Recommendation Report for Planning Permission

REF NO: A/31/19/PL

LOCATION: Land between Ashurst & Badgers
Ham Manor Way
Angmering
BN16 4JQ

PROPOSAL: 1 No. two storey house (resubmission following A/87/18/PL). This application is a Departure from the Development Plan & affects a Public Right of Way.

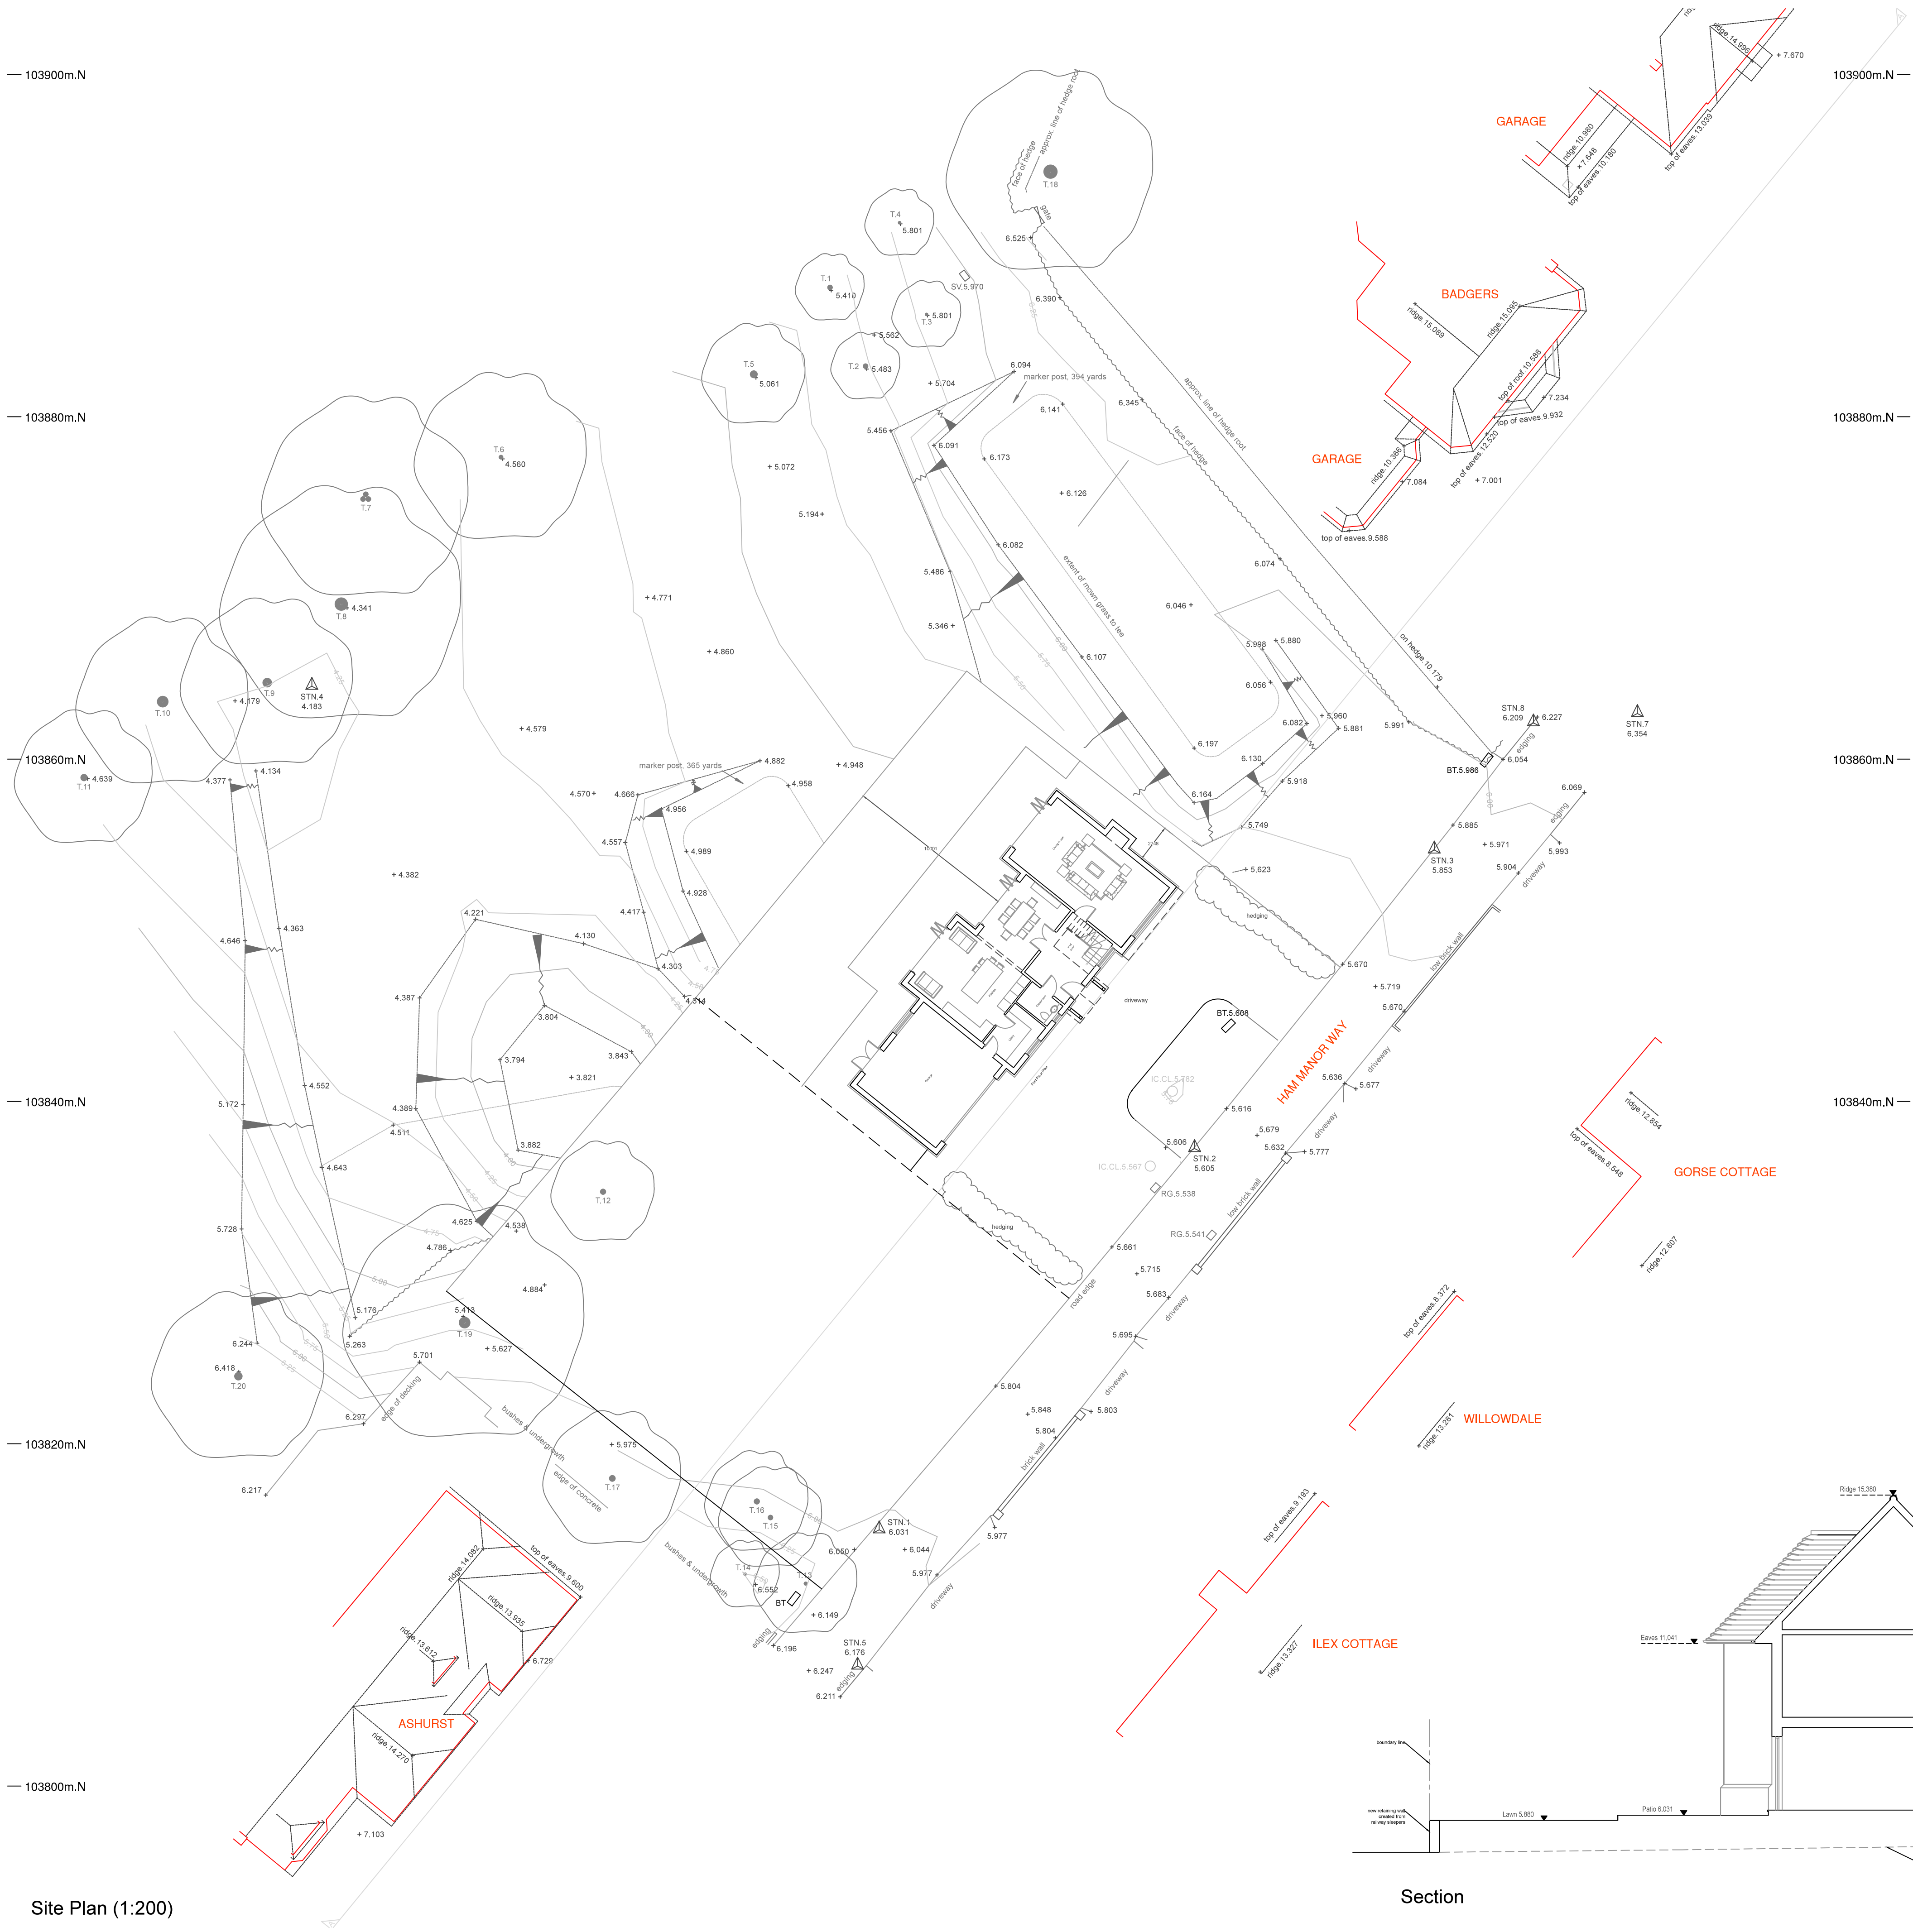
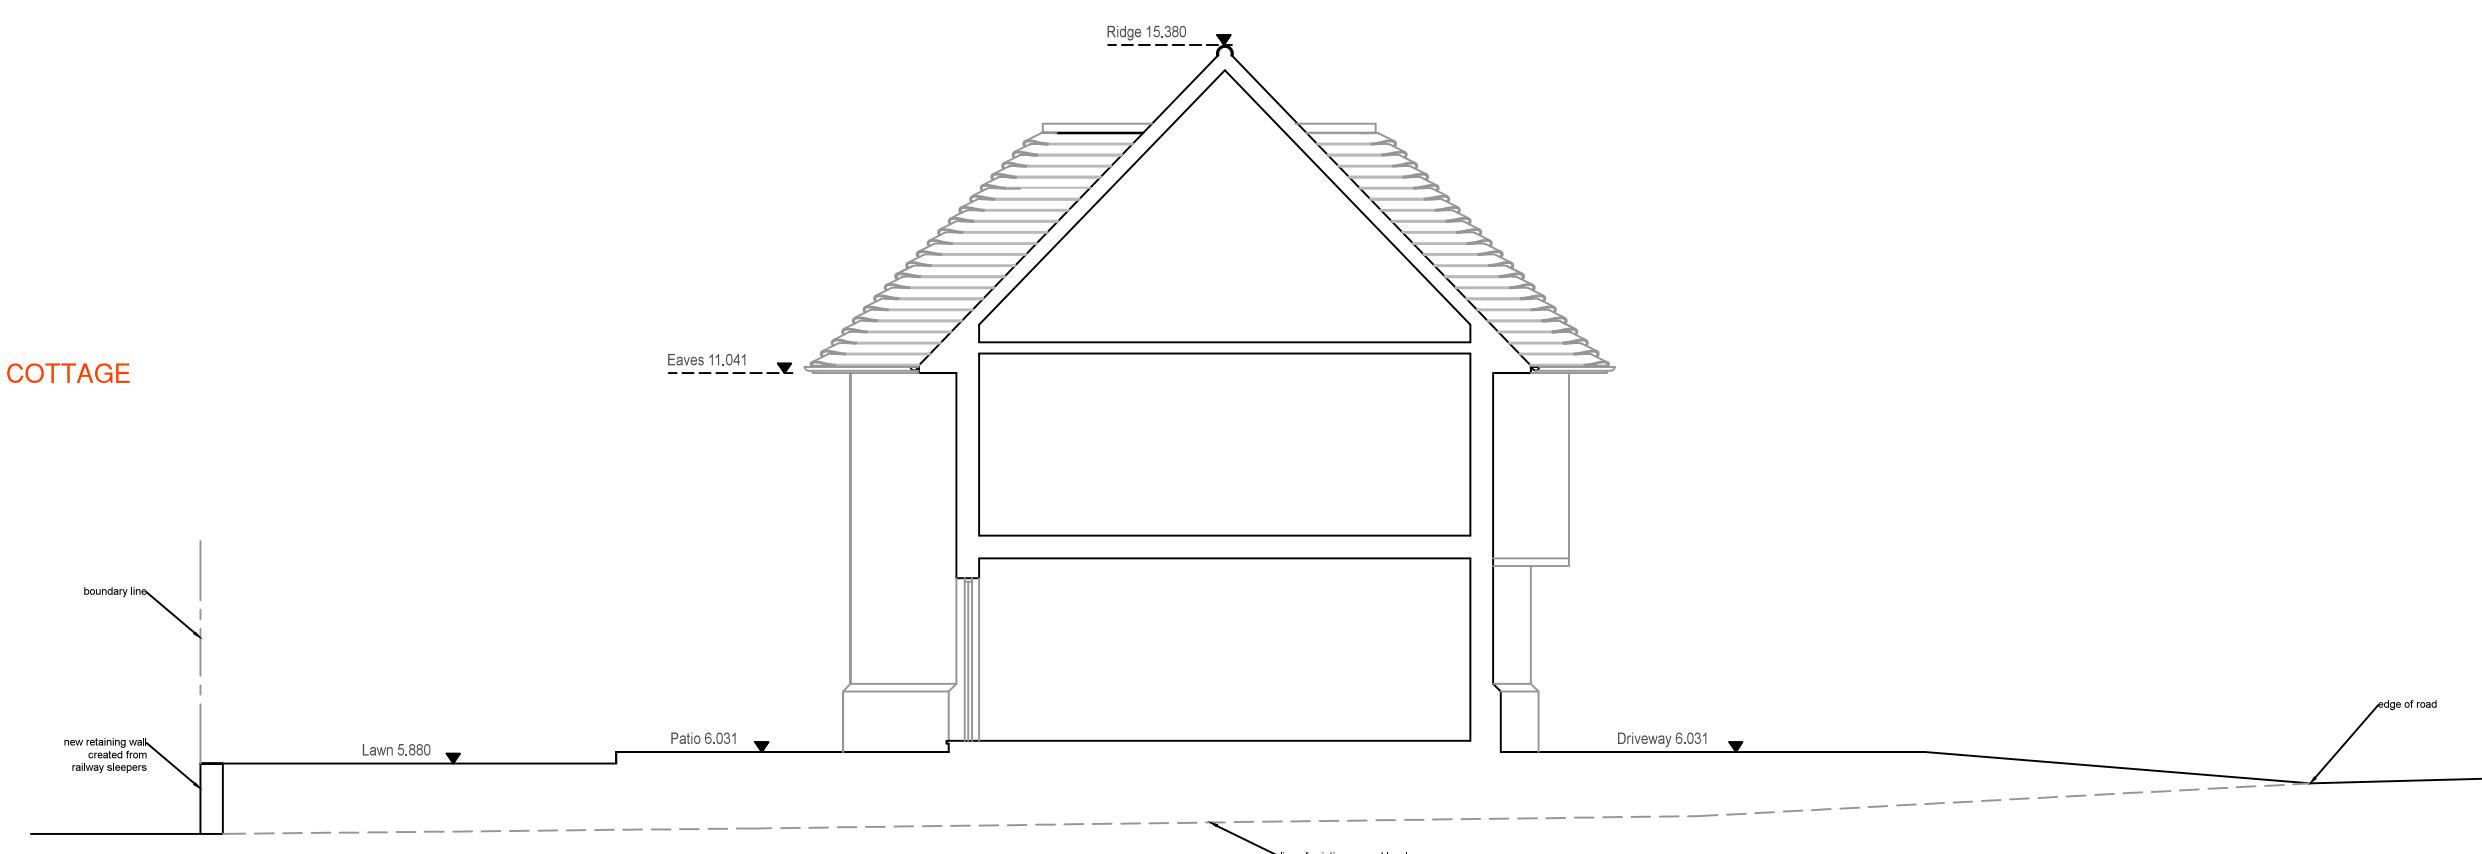
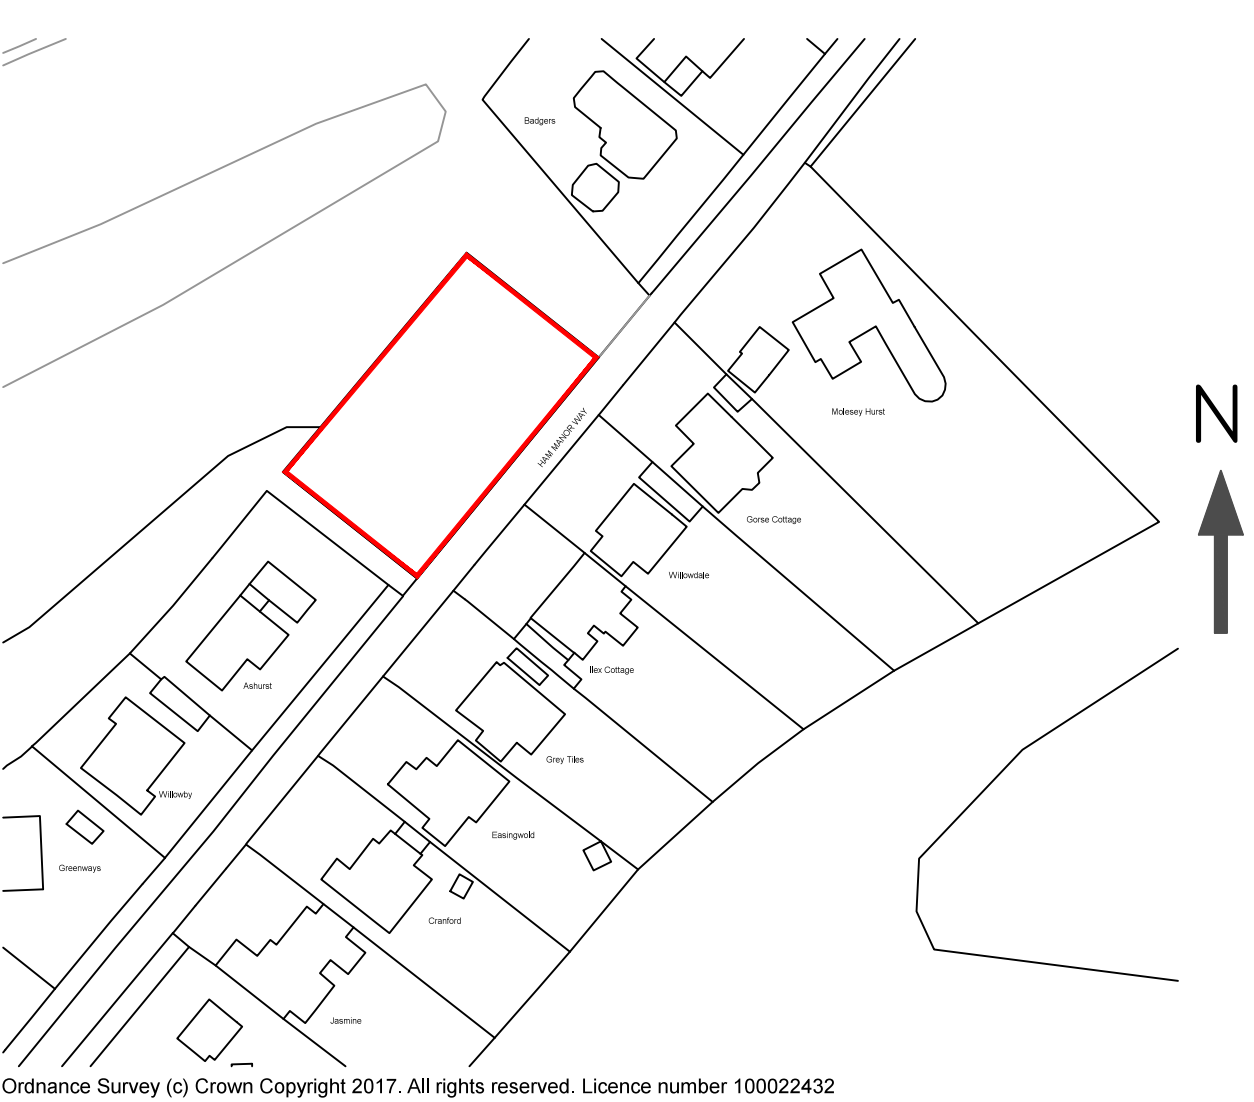
The site comprises an area of land that benefits in part from the lawful development certificate A/212/17/CLP. The relevant CLP refers to a slightly different site area, which is 2m wider than that now proposed and approx. 56 sqm larger. The site outlined is approximately 0.6m closer to the south western boundary and 1.5m closer to the north eastern boundary. This planning history is a material planning consideration. Although the site is outside the built up area boundary the recent Certificate of Lawfulness acknowledged that part of the application site has the benefit of an extant planning approval and development in this part of the site would therefore be acceptable in principle. However the application site is not confined to the approved limits of the Certificate and represents an incursion into a rural area and open space which would be contrary to policy and would result in material harm to the character of the open undeveloped area by extending the lawful residential curtilage into the golf course in a manner which would be readily visible from the public footpath. Whilst the principle of some form of development on the majority of the site has been established by the fallback position of the Lawful Development Certificate, the harm caused to the character of the area by the fallback would be less than the harm caused by the proposal.

The proposed dwelling has a similar set back from the site frontage as the existing dwelling to the south. The proposed dwelling would provide separation distances to side site boundaries in excess of 18m which are sufficient to prevent any materially adverse overbearing or overlooking effects to either of the existing residential properties to the north or south.

- 1 Given the position of the dwelling within the established golf course which is outside the built up area boundary and designated as a Local Green Space in the Angmering Neighbourhood Development Plan the increase in width of the site closer to neighbouring side boundaries would represent an unacceptable incursion into the area and would constitute a prominent form of development which would adversely affect the character and appearance of the area in conflict with policies CSP1, DDM1 and OSR DM1 of the Arun Local Plan and policies HD5
